29 May 2026

2210899

**Response to Request for Additional Information –SSD-67895459-MOD-4
106 & 120-122 Smith St And 3a Charlotte St, Wollongong
Shop Top Housing with In-fill Affordable Housing**

Figure 7 *Flinders Street South sub-precinct – Proposed Building heights*

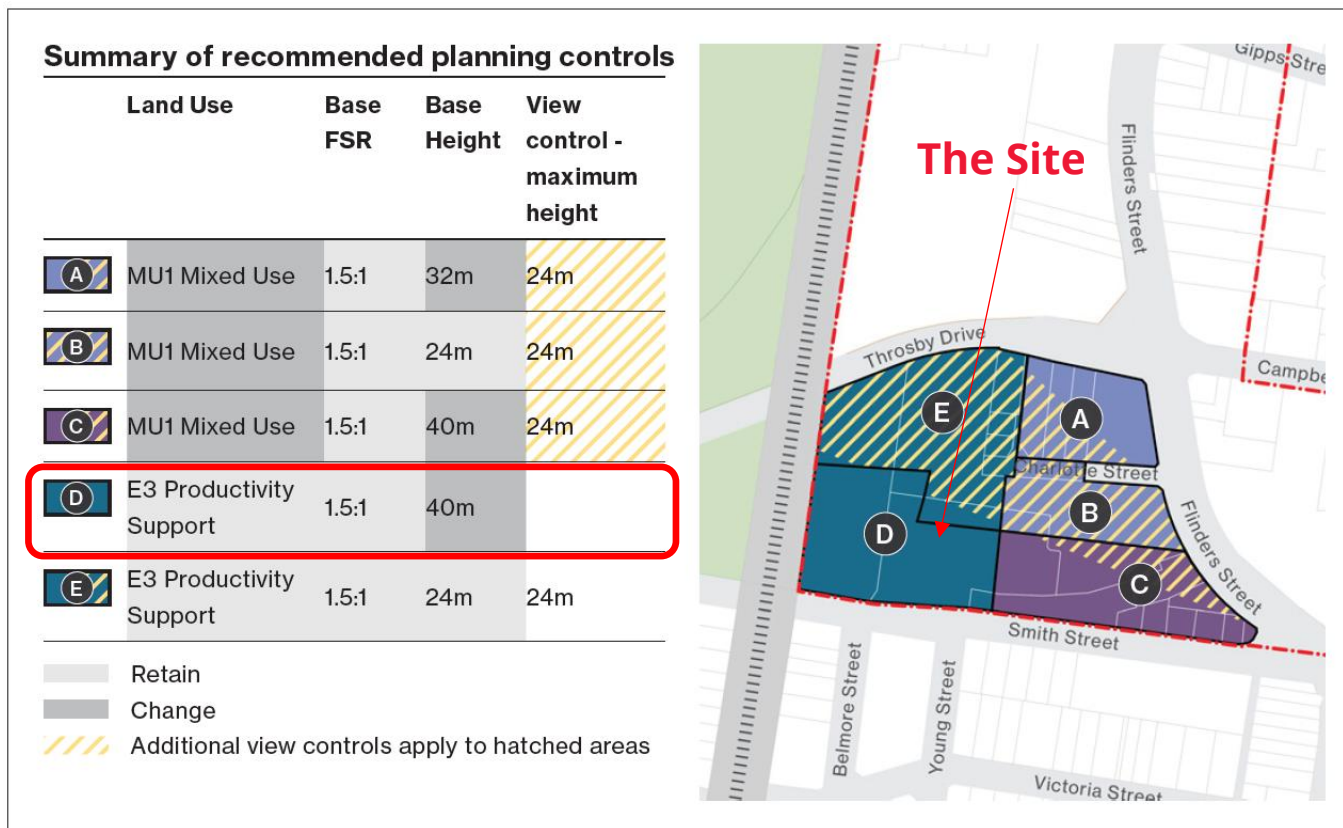
9.	<i>The site sits within areas D and E as shown on Figure 37 of the Draft UDF. Note, the white lot boundaries in Figure 37 do not reflect current lot boundaries. Figure 7 in the Collier's report does not accurately show the site or specifically Building 2, where the extra 3 storeys are proposed. The Colliers report incorrectly states that the site is subject to a 40m height control in the UDF, however Building 2 is located within the 24m hatched area. It may be helpful for assessment if the applicant provides a plan showing the site superimposed on Draft UDF Figure 37. The applicant's Team 2 Architects plan DA-0200 Rev 3 dated 5 December 2025 shows the site's northern boundary is a continuation of Charlotte Street.</i>	Noted. The location of the proposed additional building height is located substantively within the area categorised for a base height of 40m. For the reasons set out in the view assessment within the Planning Report and Appendix E of the Planning Report, additional building height in this location, including to the north-western corner of Building 2, does not result in any impact of to the preservation of the key view corridor to Mt Keira.

Figure 15 Western Elevation – building height

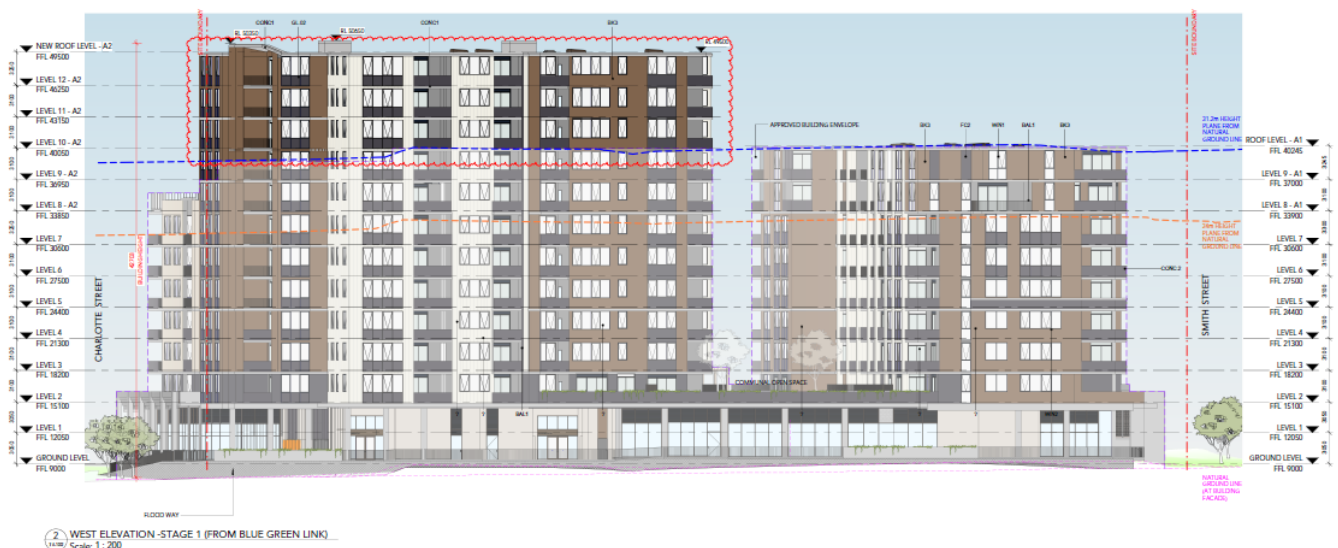
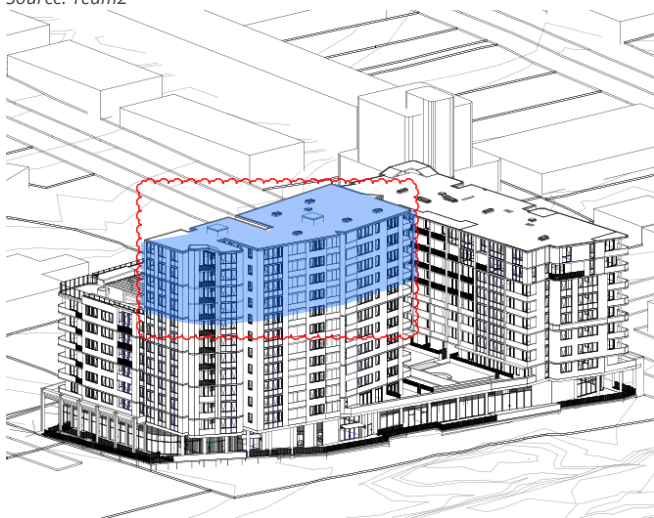
3.	The proposed modification would result in Building 2 having a building height of 41.655m. This exceeds the maximum 24m height permitted in Wollongong Local Environmental Plan 2009 and 24m in Council's exhibited Draft Flinders Street Urban Design Framework (Draft UDF). It also exceeds the maximum 30% affordable housing height bonus provided under State Environmental Planning Policy (Housing) 2021, which limits height to 31.2m.	The proposal is entirely consistent with the anticipated height of the site under the UDF at 40m (with minor elements only above 40m), which sees the proposal 'give effect' to the strategic intent of Council in the draft UDF for the Flinders Street Precinct and this block in particular. Notwithstanding, as set out in the Modification Report, the proposed building height, in relative terms to the permitted height at 31.2m is an appropriate and justified application of the flexibility afforded under the planning framework. This is particularly relevant in the context of high demand for housing (including affordable housing) from all levels of government, the site being well located, and which is demonstrated to be capable of readily accommodating additional housing in a manner which does not result in impacts either internal or external to the site.

4.	Council does not consider the applicant has adequately justified contravening the permitted height standards. The justification on pages 33 and 35 of the Colliers report does not demonstrate that compliance with the height standard is unreasonable or unnecessary in the circumstances, nor does it establish adequate planning grounds for the height exceedance. Specifically, Council notes that the proposed height is inconsistent with the Draft UDF, despite the applicant's claims of compliance.	Section 6.1 (Building Height) of the Modification Report provides assessment against the relevant provision of the Housing SEPP, outlining that the development is consistent with the objectives of the height of building development standard in Clause 4.3 of the Wollongong LEP 2009. It is noted that the building height, as measured at 42.74m. The remainder of the building parapet is below this height. As the proposal is not a Development Application, Clause 4.6 of Wollongong LEP 2009 does not apply and therefore, in specific terms, the relevant considerations under clause 4.6 to demonstrate that a variation to the development standard is "unreasonable or unnecessary" does not apply. Notwithstanding, Section 6.1 of the Modification Report sets out a detailed assessment of the proposal and building height, including consideration of Council's comment, relating to whether compliance is unreasonable or unnecessary in the circumstances, and the relevant environmental planning grounds. The Modification Report prepared does not purport that the proposal complies with the draft UDF, rather, as set out above, the Modification Report specifically addresses the non-compliance to the current height of building control. Regarding consideration of the proposal against the draft UDF:

Figure 20 Draft UDF View Line with Future Massing of Development at Smith and Flinders Street

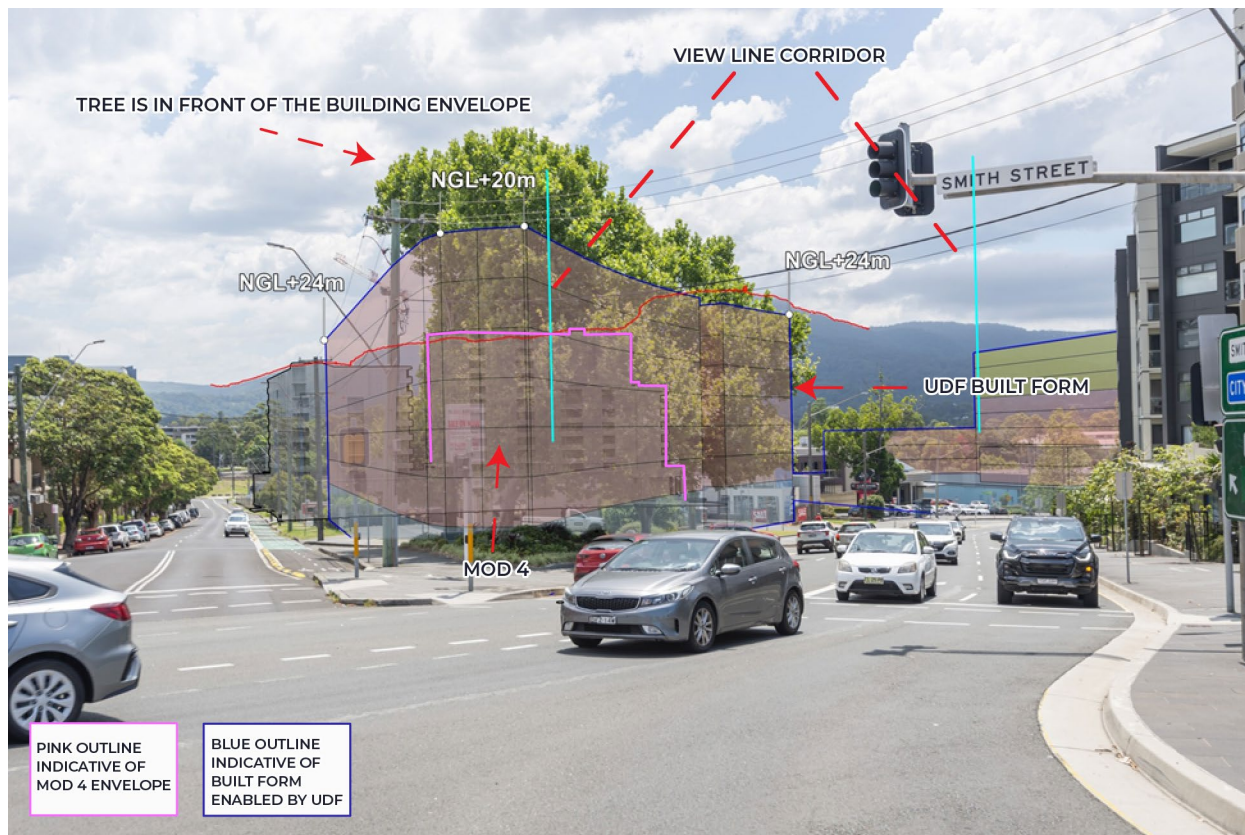
10.	<i>Views to Mount Keira from various locations within the precinct, including the Keira/Smith Street intersection, remain important and highly valued and are reflected in the Draft UDF.</i>	Noted and agreed. The Updated Visual Analysis prepared by Colliers (Appendix E) considers the potential visual impact of the proposal and addresses the requirements of the SEARs. This assessment confirms that the proposed modification does not generate new or additional impacts that would give grounds to not support the proposal in accordance with the Department's original conclusion of the development, as follows:

It is the findings of this report that the proposed modification would be visually blocked in its entirety by potential future development of the corner site when viewed from the corner of Smith and Flinders Streets as demonstrated in the below photomontage.

The additional floors proposed in MOD 4 will not be visible from the UDF viewpoint in the future Flinders Street Precinct context or the existing controls which permit up to 24m buildings. This remains the case even if future buildings do not receive a 30% AH bonus and stay below the 24m view cone height, which aligns with the existing height limit. Furthermore, future context buildings are positioned behind an existing cluster of mature trees, which fully obscures the proposal from the UDF view corridor.

Solar Access Diagram

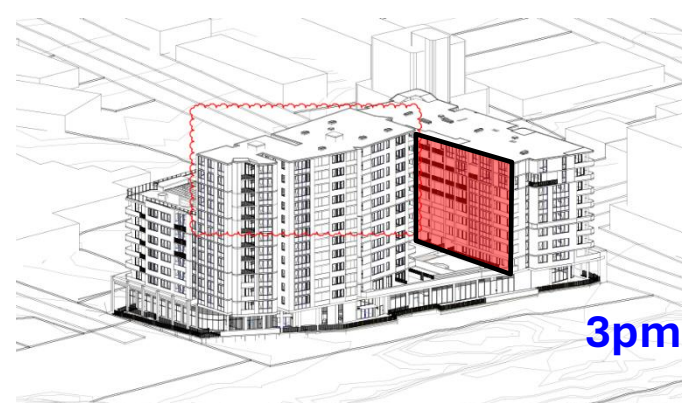
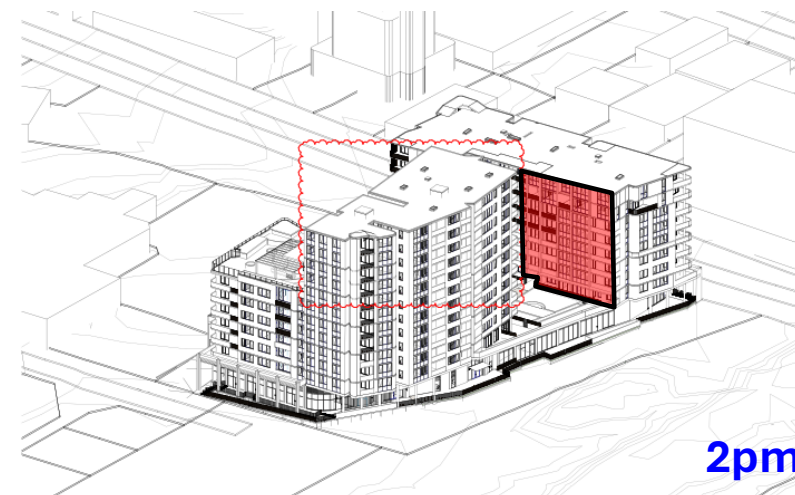
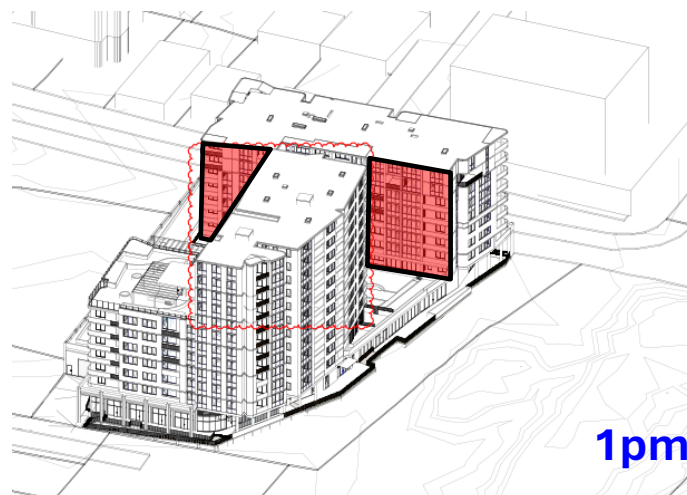
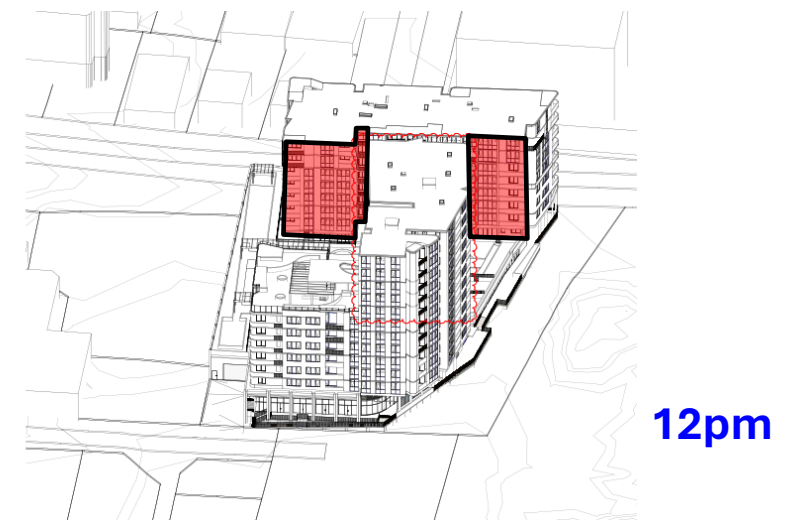
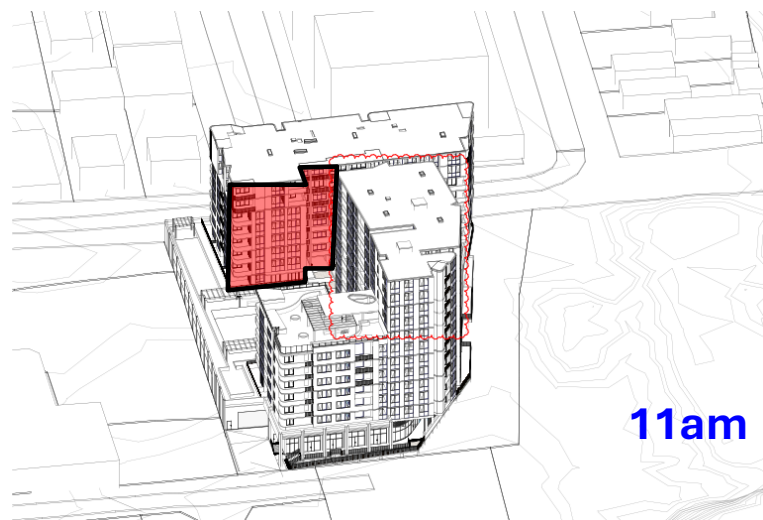
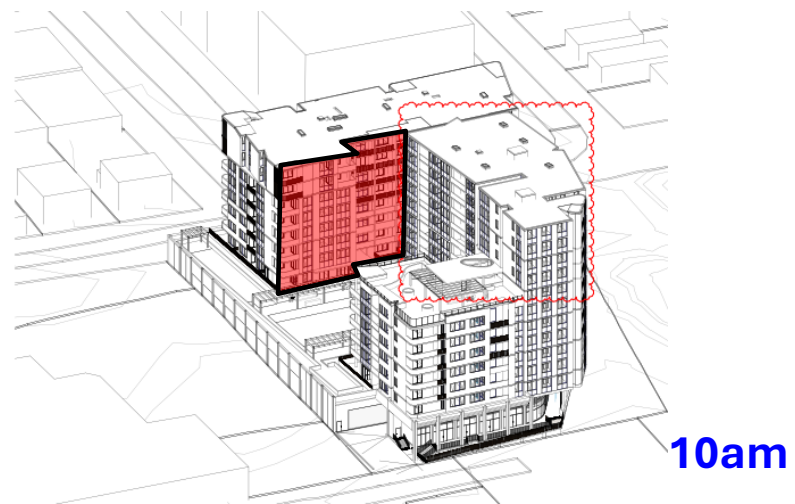
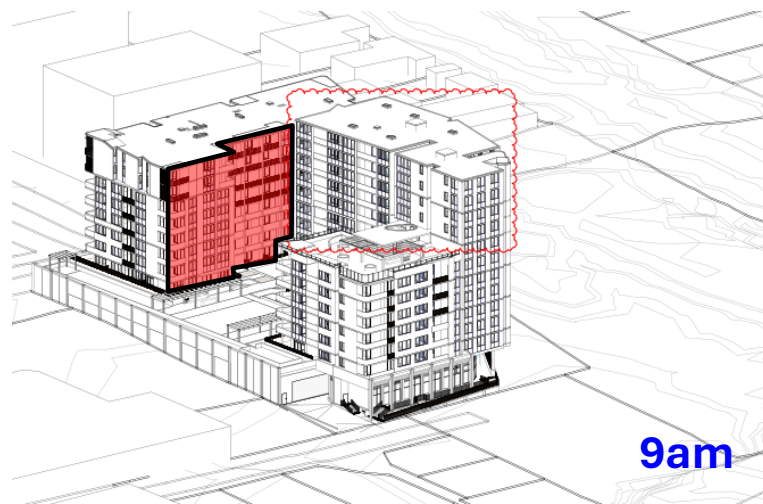
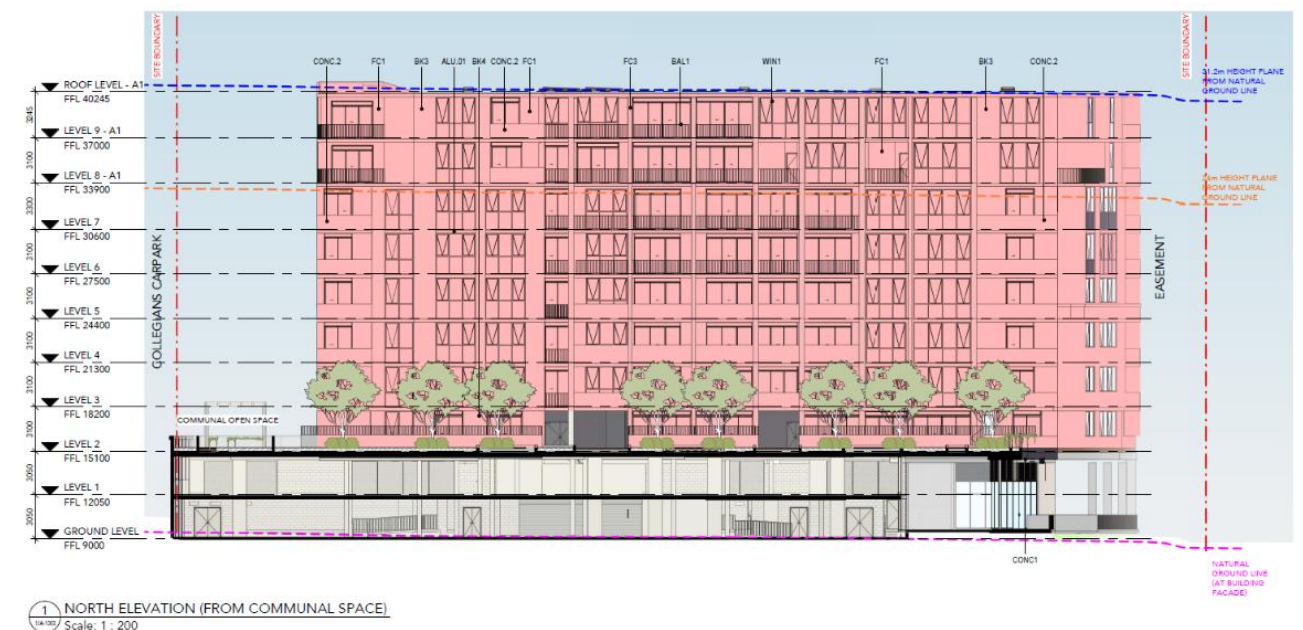
6.	<i>It should also be noted that providing the uplift on the northern tower would result in additional overshadowing to the Building 1 (and in turn possible reduced amenity and solar non-compliance for units within the Building 1).</i>	Section 6.5 (Solar Access and Overshadowing) of the Planning Report confirms that the proposed built form amendments do not result in any additional adverse impacts within the site (or adjoining properties). Locating additional height to the northwestern corner of the site provides a unique opportunity to maintain and maximise on site residential amenity and housing provision in the region, whilst not generating any additional overshadowing to surrounding dwellings, including the existing resident building to the south of Smith Street. Similarly, the proposal does not impact the podium open space beyond the existing approval (as measured in mid-winter) due to the orientation of the site (and path of the sun), as seen through the analysis of the original proposal and proposed development view from the sun diagrams. Annotated extracts of the view from the sun diagrams (Appendix A), are provided below that demonstrates the lack of any external amenity impacts. Furthermore, the shadow diagrams provided at Appendix A of the Modification Report confirms that the development, as proposed to be amended, maintains more than 70% solar access to apartments in mid-winter. More specifically, Building 1 achieves 87.1% (as set out in Appendix C of the Modification Report)

Item	Matters Raised	Proposed Response - Summary
		and shown on Sheets DA-8302 and DA-8304 of Appendix A of the Planning Report – Provided at Attachment C .
